From: Nolan, Chris <Chris.Nolan@lancashire.gov.uk>
Sent: 09 October 2017 10:24
To: Adam Birkett; planning
Cc: LHS Customer Service
Subject: D3.2017.0813 - Dale Hey Bungalow Preston Road Ribchester

Planning Application No: 3/2017/0813

Proposal: Proposed new road access and driveway to garage at rear of premises.

Location: Dale Hey Bungalow Preston Road Ribchester PR3 3XL

Dale Hey Bungalow
 Preston Road
 Ribchester
 PR3 3XL *PROPOSED NEW ACCESS AND DRIVEWAY TO GARAGE*
 DDG REF 2317 CB/RF.

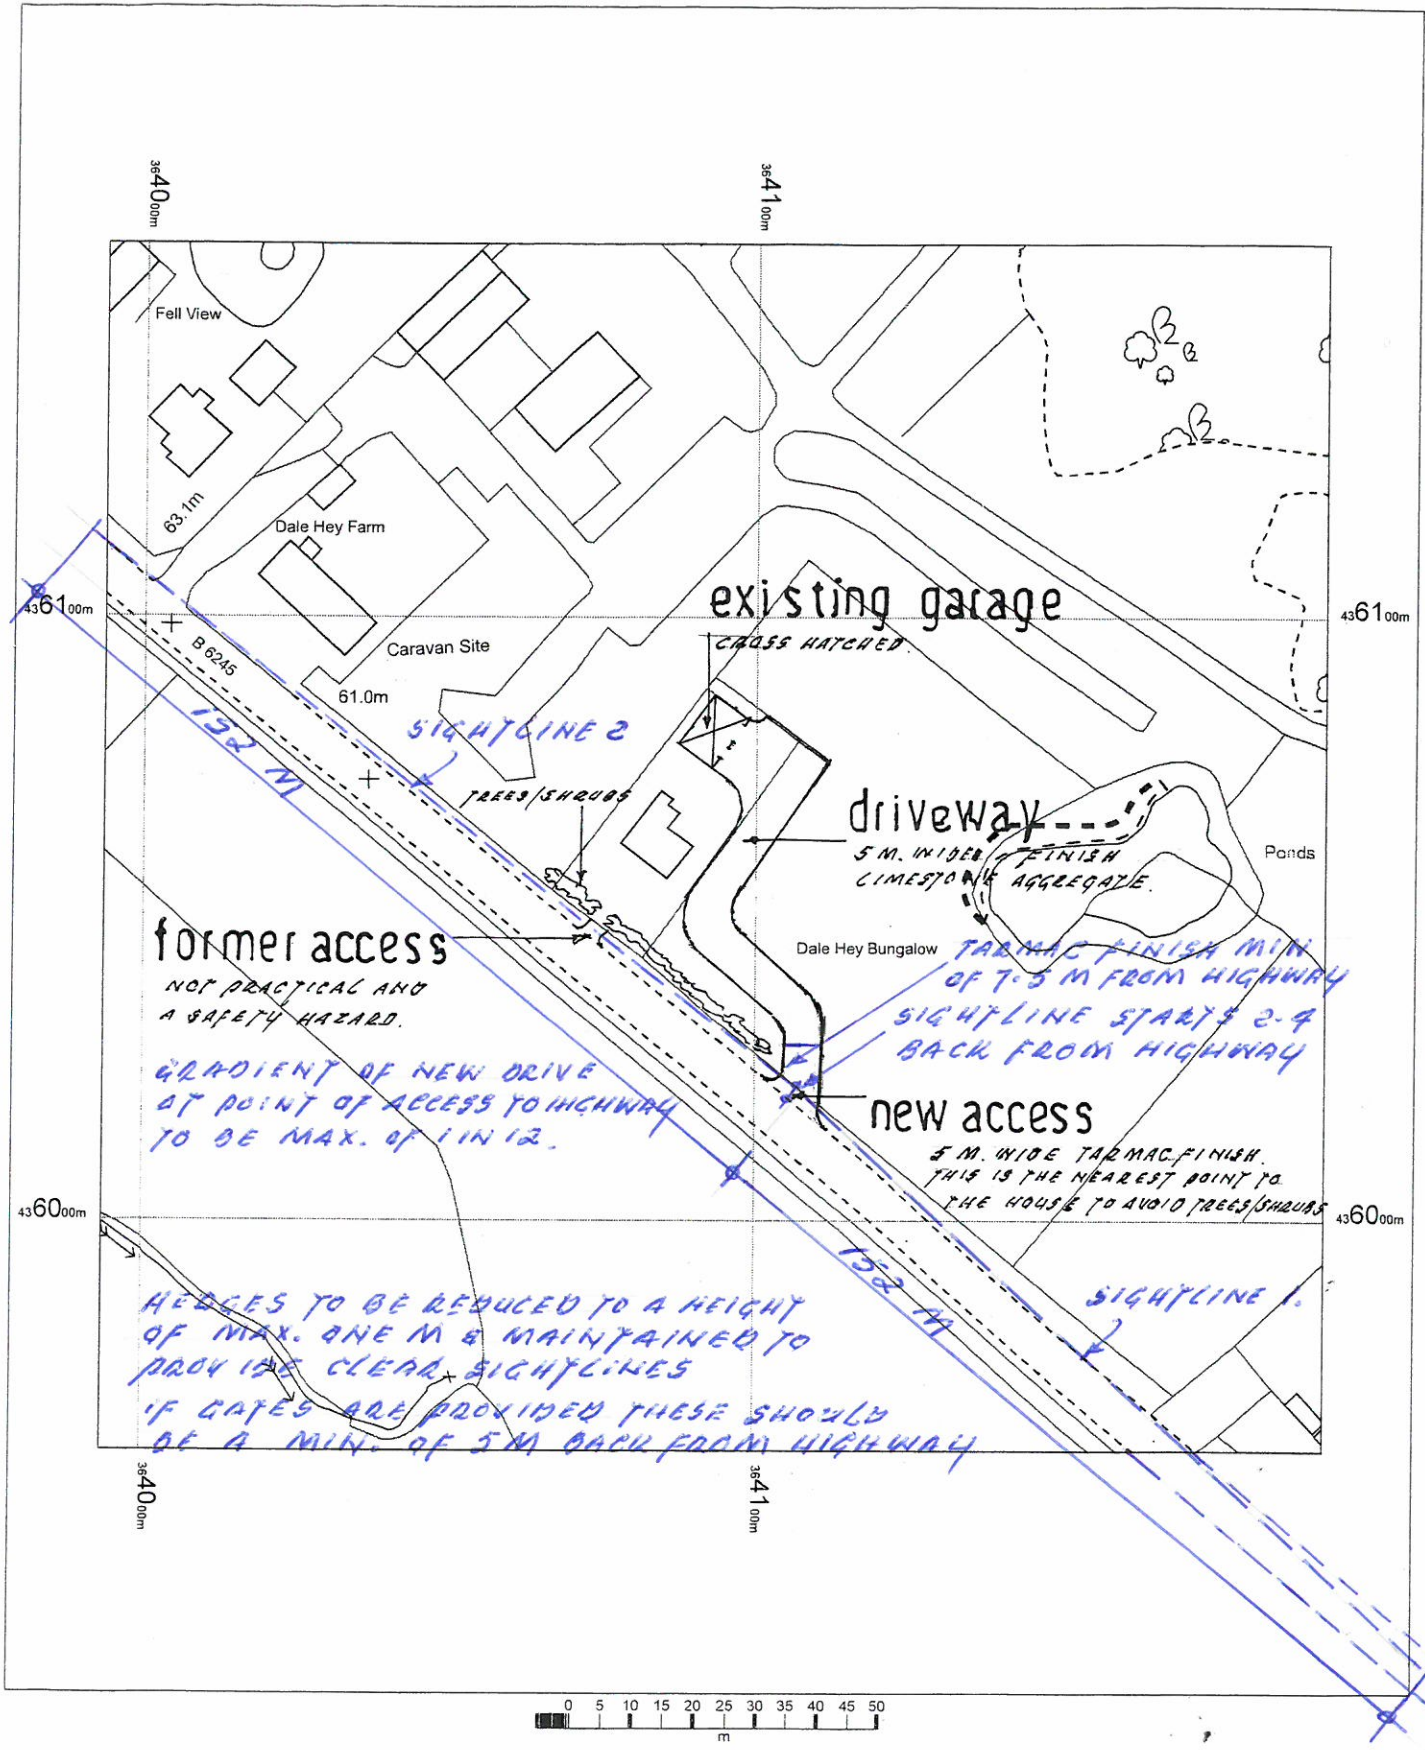
The application indicates a former access that is not practical and a safety hazard. This point is not a vehicle access and should be disregarded. Presently access seems to be gained via a field gate off the road. This is not suitable for regular use as there is no facility to pull off the road before opening the gate and the sight lines when leaving the site are below the standard for a road of this type.

The length of Preston Road alongside Dale Hey Bungalow is a derestricted road with a maximum speed limit of 60 mph and with the good sightlines high speeds would be expected. This being the case I would be looking for sightlines both sides of the junction of 200m if possible and at least 152m as an absolute minimum. These sightlines would need to be possible from a point that is 2.4m back from the edge of the highway. Such work may require some of the hedges to be reduced to and maintained at a height not exceeding 1 m.

A site inspection indicated that there may be a difference between the level of the field and the carriageway on Preston Road. This would need to be indicated on a new plan along with measures that will be undertaken to ensure safe and easy access and egress.

1. That alterations will be undertaken to achieve the necessary sight lines at the point of access.
2. The plan indicates that there will be at least 7.5 m of bound surface between the edge of the highway and limestone aggregate road.
3. Any gates will be placed at least 5 m back from the edge of the highway to ensure that any vehicle can pull completely clear of B6245 Preston Road prior to opening the gate. If vehicles of longer than 5m are expected to use this access point when it is completed or in the foreseeable future then the gates should be further set back to ensure that these vehicles can pull clear of Preston Road prior to the need to stop for opening any gates.
4. Plans will need to indicate a cross section of the access point indicating the gradient of the new drive at the point of access to the highway.
